PLANNING CONSULTATION RESPONSE

Application No	2025/0727
Proposal	Discharge of condition 4 relating to application 2025/0338 (Upward extension to convert existing bungalow into two storey dwellinghouse (Prior Notification - proposed enlargement of a dwellinghouse by constructing additional storeys Class AA))
Address	Gravels Farm Bungalow, Gravels Farm Schole Hill Lane, Penistone, Sheffield, S36 9AW
Date of Consultation Reply	04/02/26
Consultee	Highways Development Control

Thank you for consulting Highways Development Control on this discharge of condition application which is seeking to discharge condition 4 – Construction Method Statement.

Proposed Block Plan

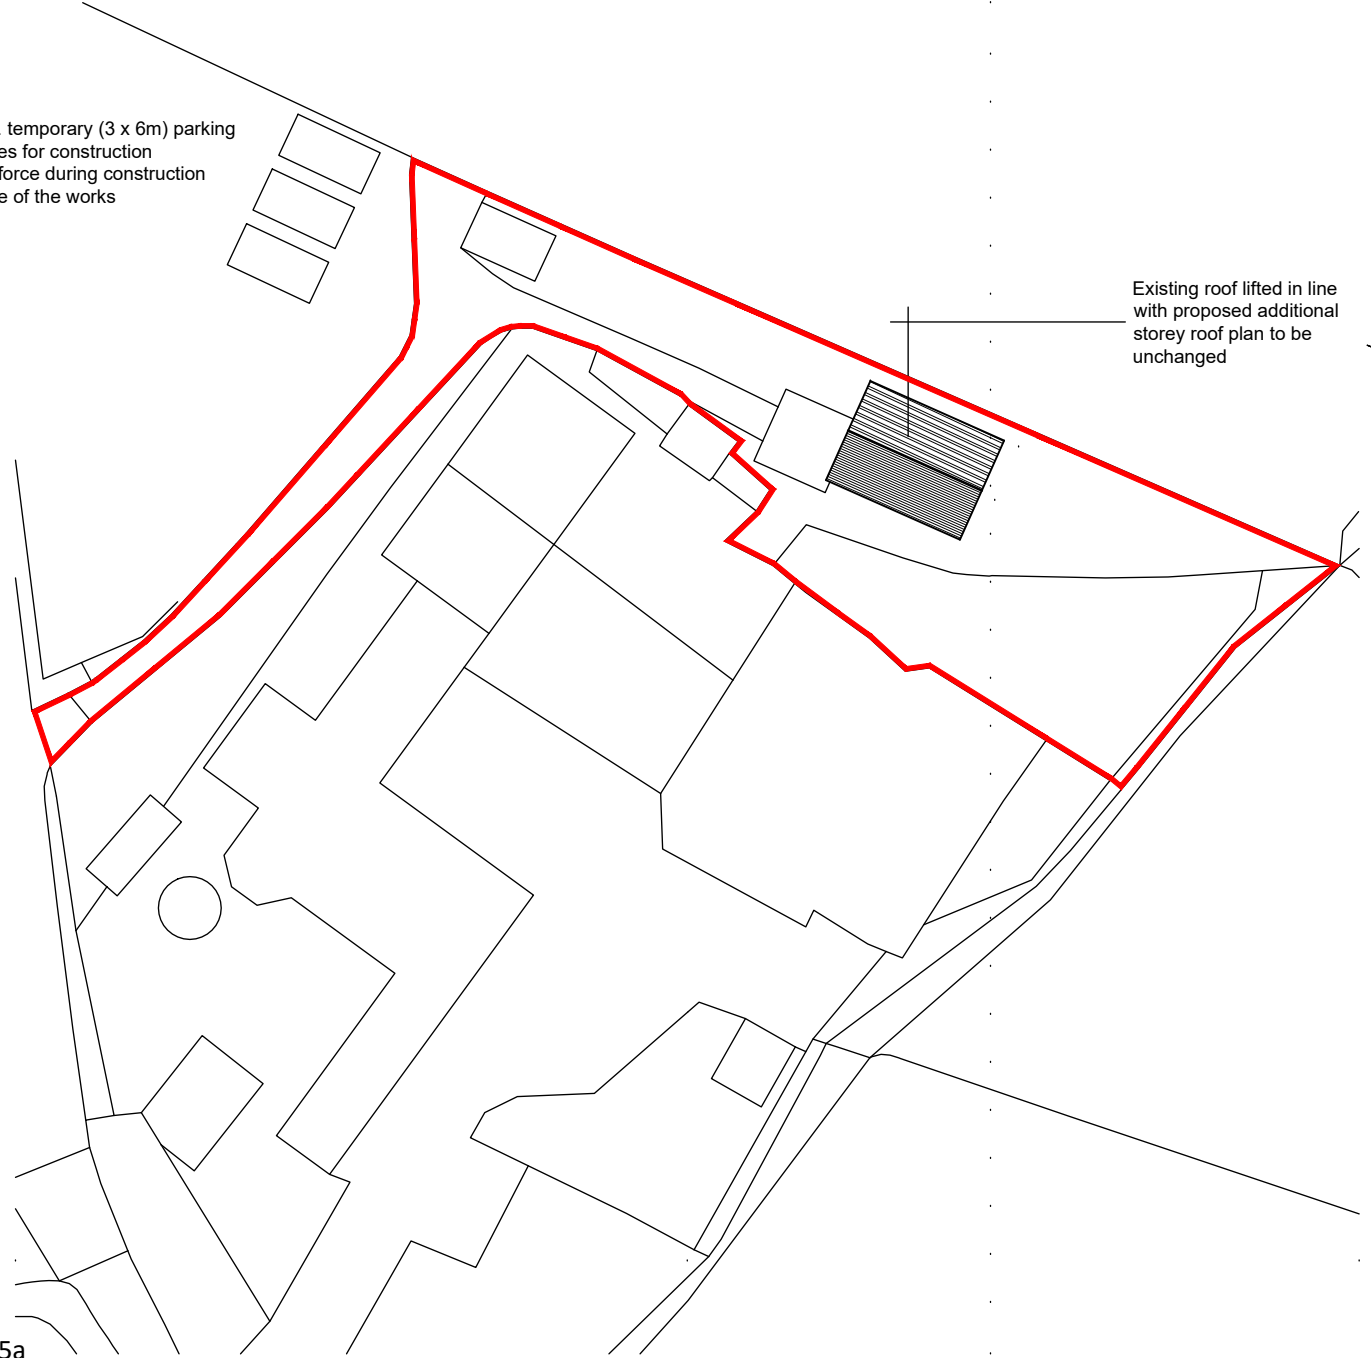
Whilst the applicant states that they do not foresee any issues with mud and debris being transferred to the highway and as such do not propose wheel washing. Any transfer of mud or debris would be seen as a failure of this document and as such, mitigation should be in place in the rare even that this will happen. As such, I would like to see this reflected in the document by way of mitigation in the instance that this does occur. This can be as simple as wheels being washed off with a hose.
